Hillingdon Water Sports Facility and Activity Centre - Broadwater Lake

Environmental Impact Assessment Scoping Opinion

Reference: 294428-01

Final | 18 May 2022

Figure 1.2: Indicative Planning Application Site Boundary

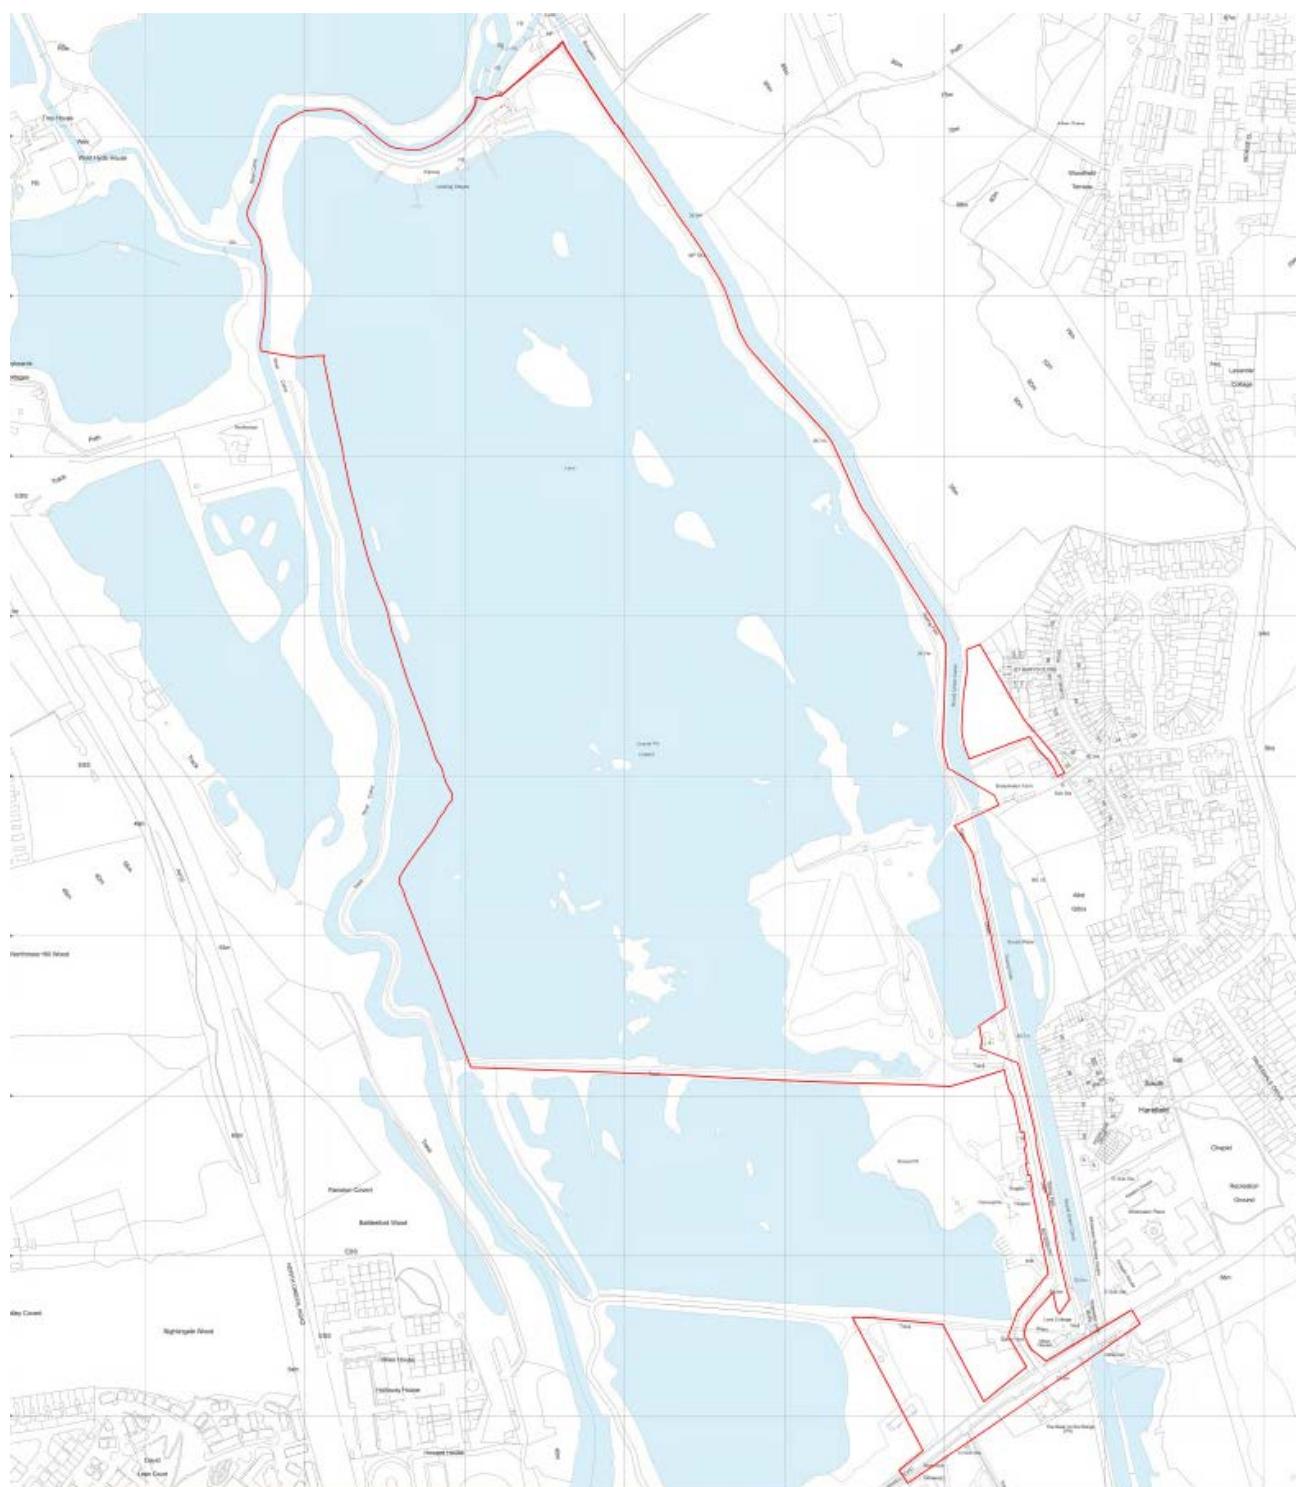
1.4.4 The proposed planning application boundary is shown in Figure 1.2 of the Scoping Report. The ES figure should be updated to show to location of the various parcels, i.e., 'south parcel' and 'east parcel' within the planning application site.
